29 February 2016

**Re: Proposed Research and Education Facility at Taronga Zoo (SSD 7311)**

I am writing to advise that Council has reviewed the Environmental Impact Statement for the development of a research and education facility at Taronga Zoo and the following issues are noted:

Drawing Title
Level 1 (Lower Ground)

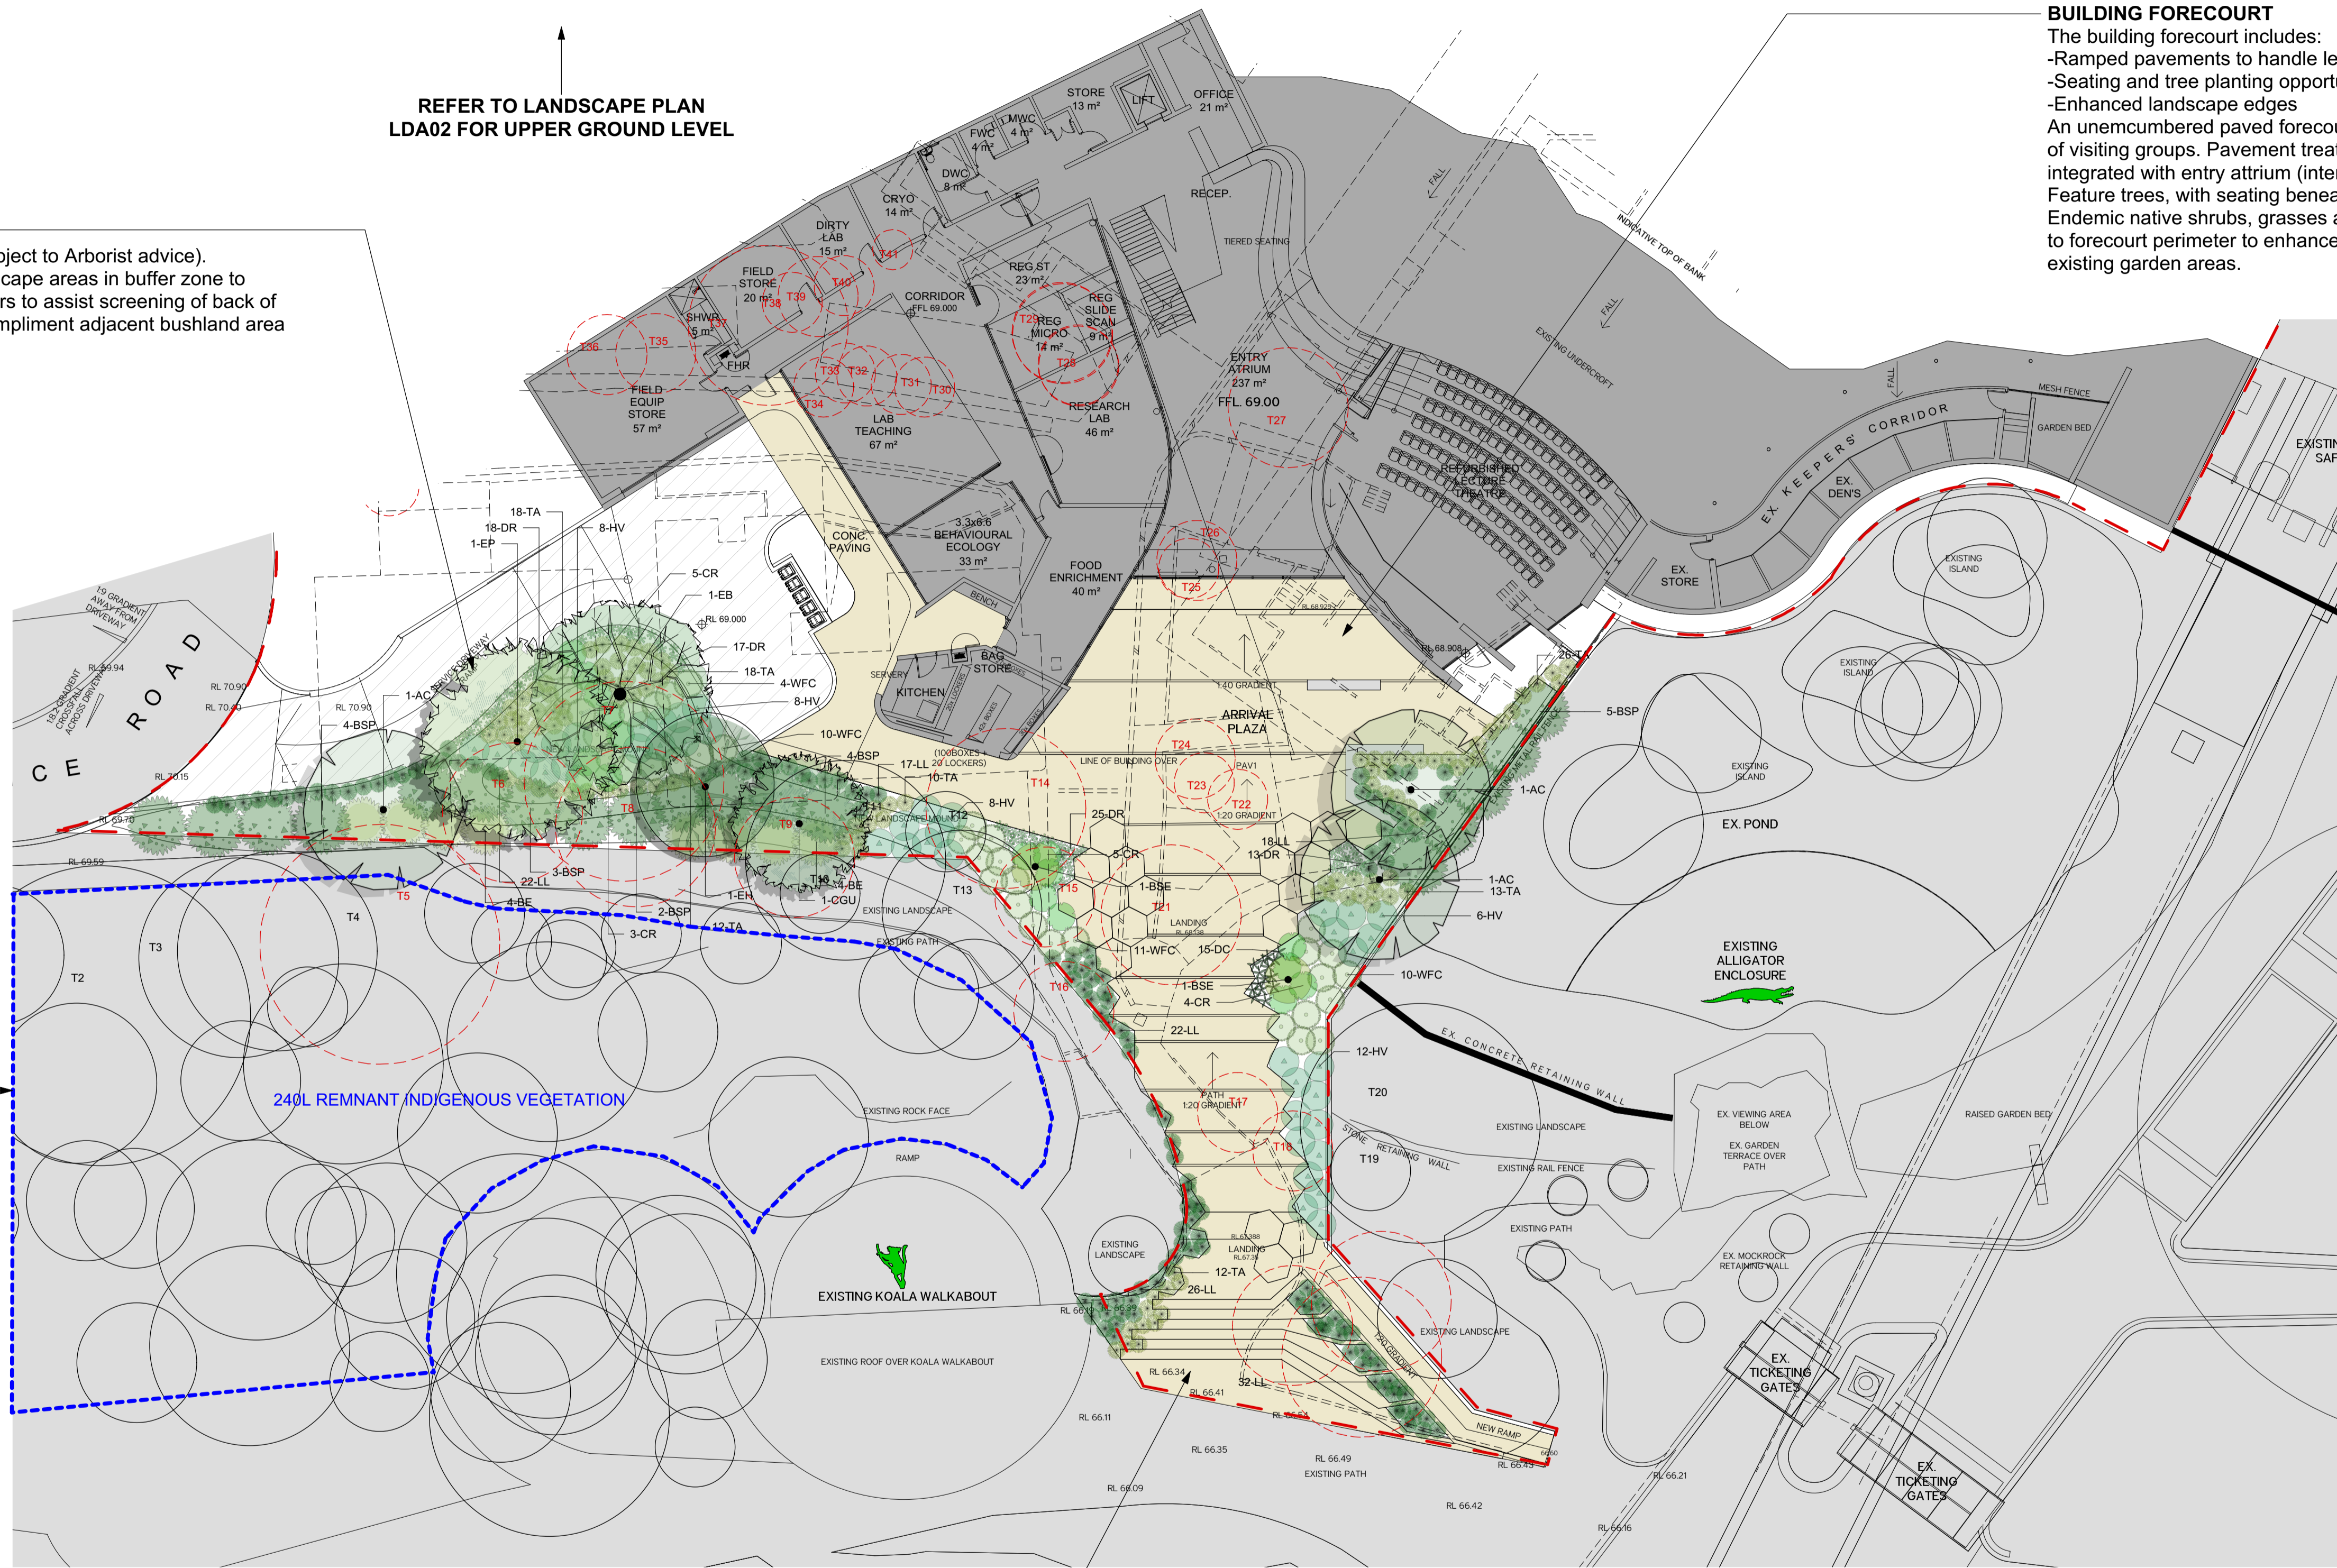
- The photomontage of the new building when viewed from Curraghbeena Park (pg. 42) shows that existing and proposed landscaping will appropriately screen the building. It is not clear if the requirements of the Bushfire Assessment (pg. 49) which specifies the provision of an Asset Protection Zone will impact on the extent of landscaping to be retained/provided. The visual dominance of landscape over buildings is strongly encouraged on harbour foreshore sites.
